Application for Removal or Variation of a Condition following Grant of Planning Permission or  
Listed Building Consent

Erection of a new 1 bed, two storey dwelling - It forms a side extension to the west of 10 Reid Close

20/03023/F

5

TITLE:  
**Proposed Ground Floor Plan**

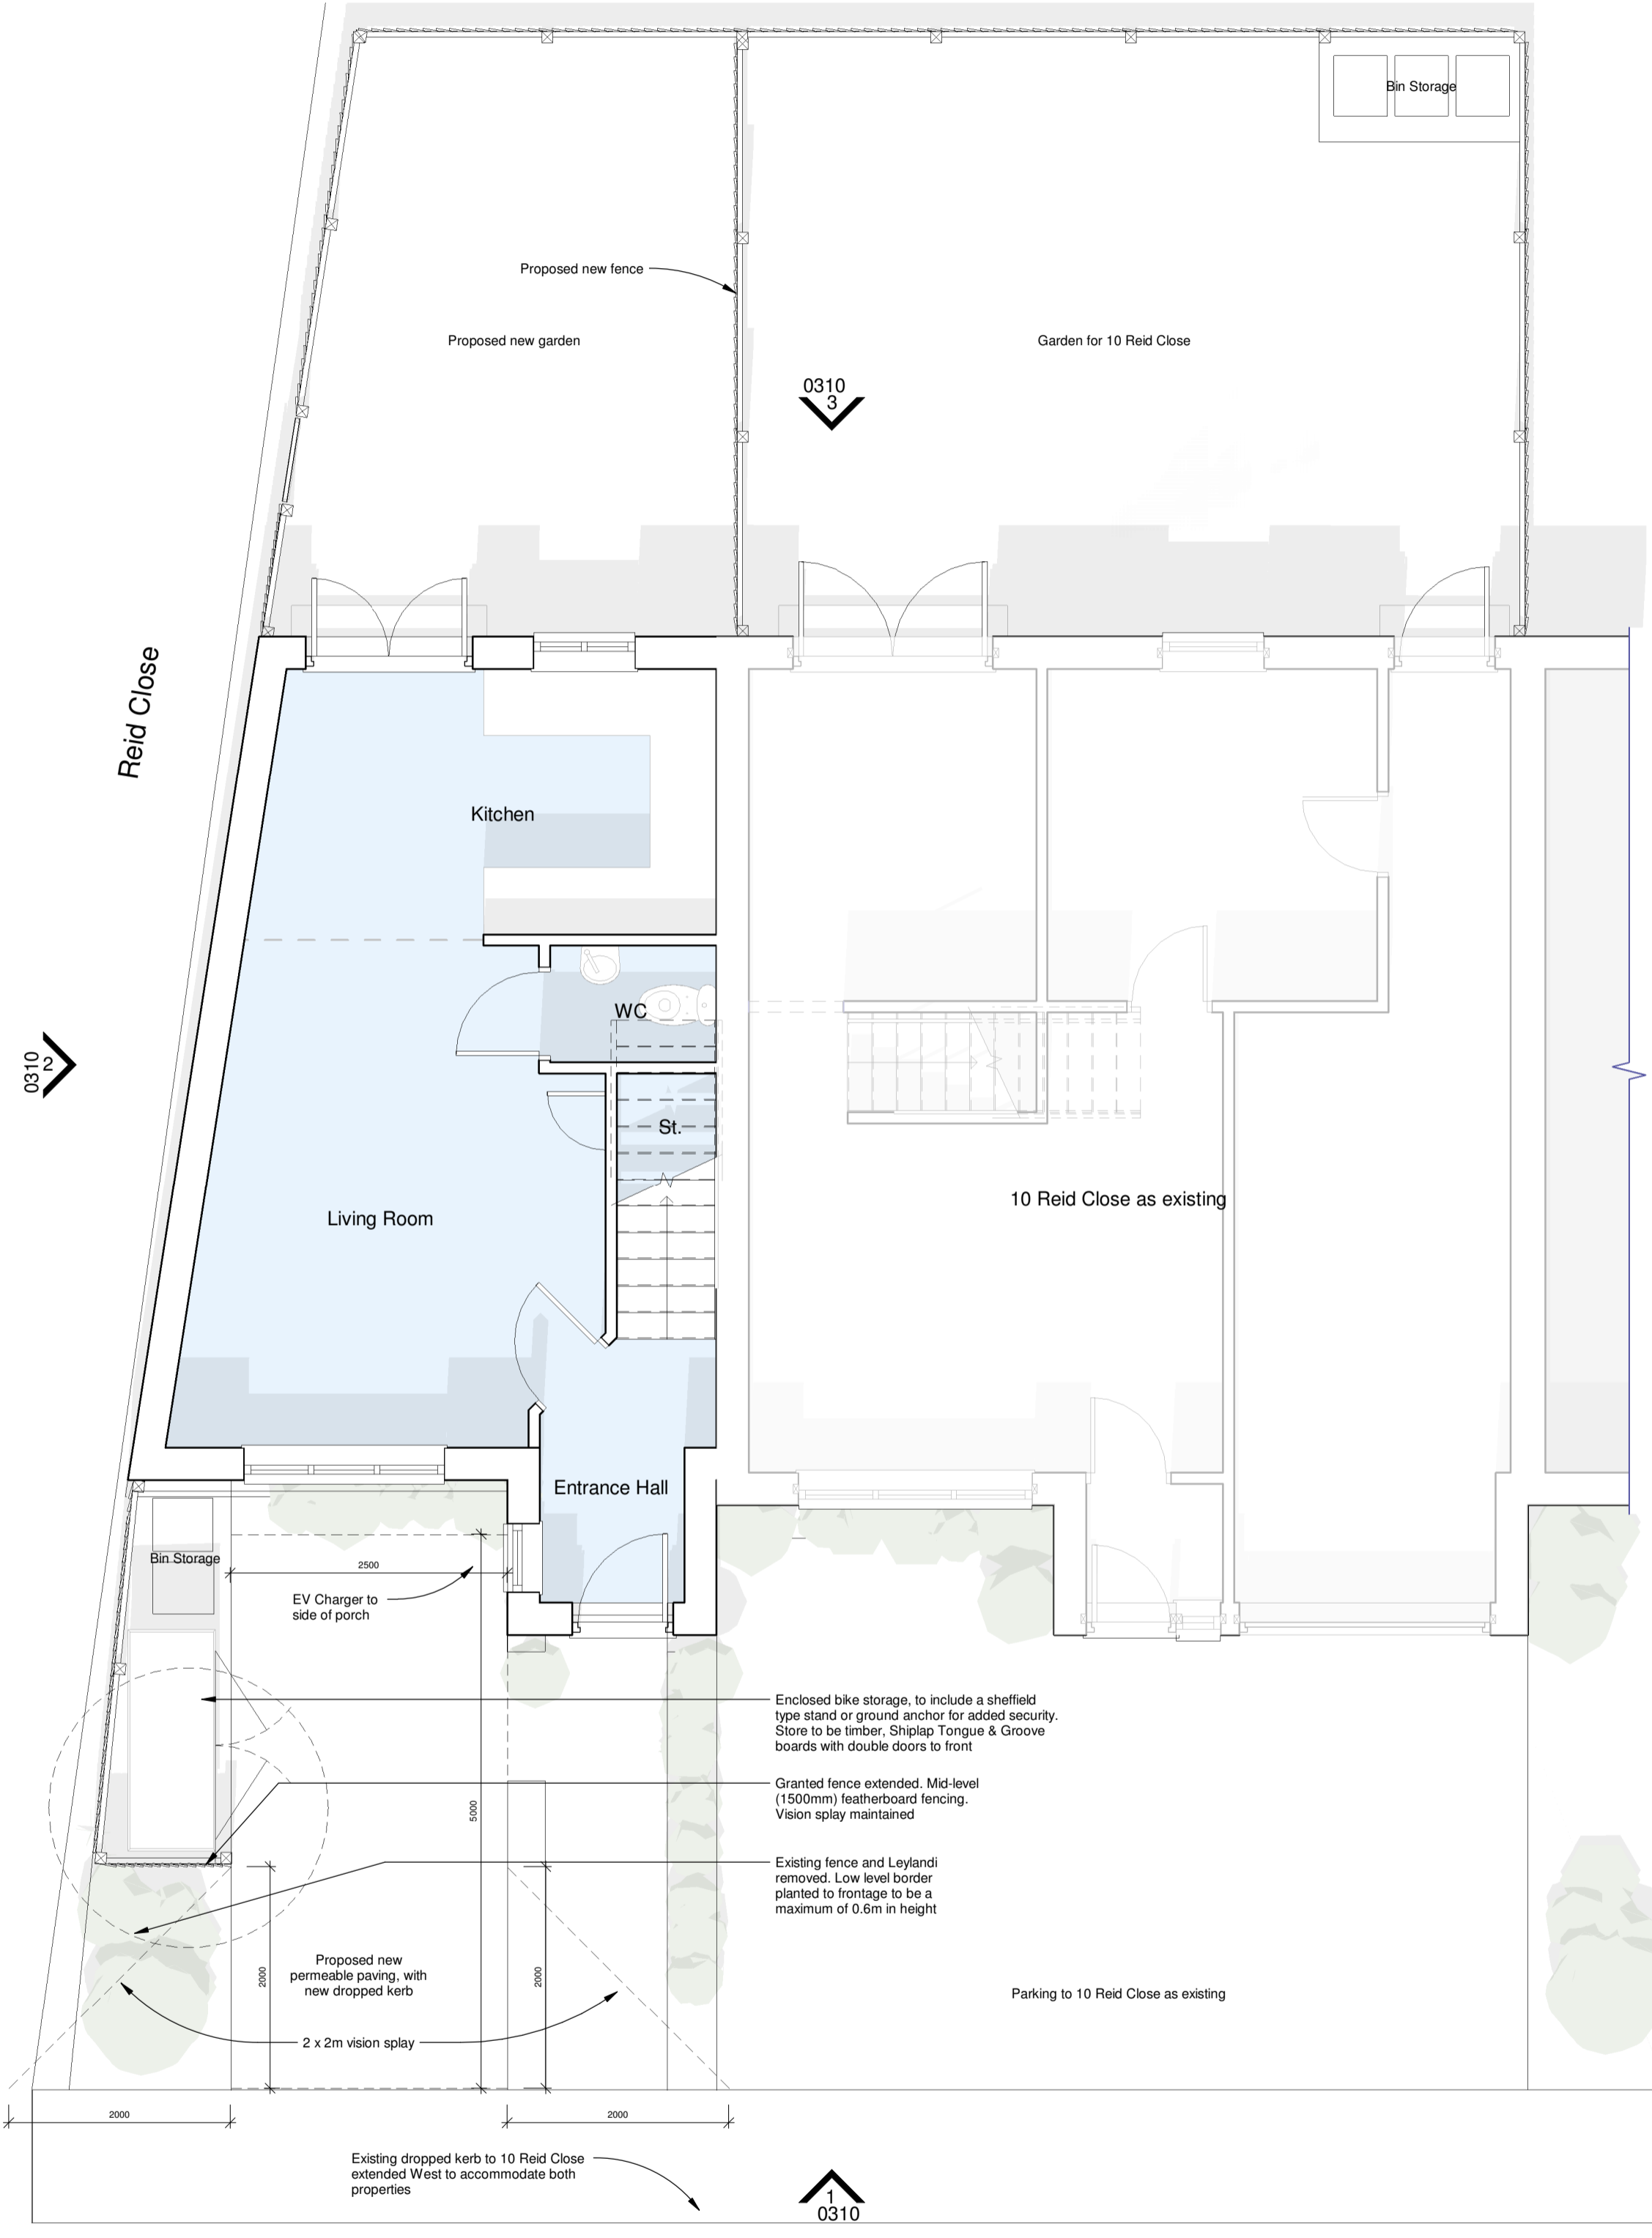
Changed - The bicycle storage is required to move to the front of the property.  
The proposed right of way to the rear garden in the original application is currently not viable. Therefore, a new solution for secure bicycle storage needs to be found.

The applicant wishes to amended the position of the cycle storage to the front of the property, to be along with the bins. The granted fencing has been increased slightly and the vision splays have been maintained. Please see drawing 1010\_FCA\_XX\_00\_PL\_A\_0110\_P05 Proposed Ground Floor Plan.

The storage type is to be an enclosed bike store, including a Sheffield type stand or ground anchor for added security.
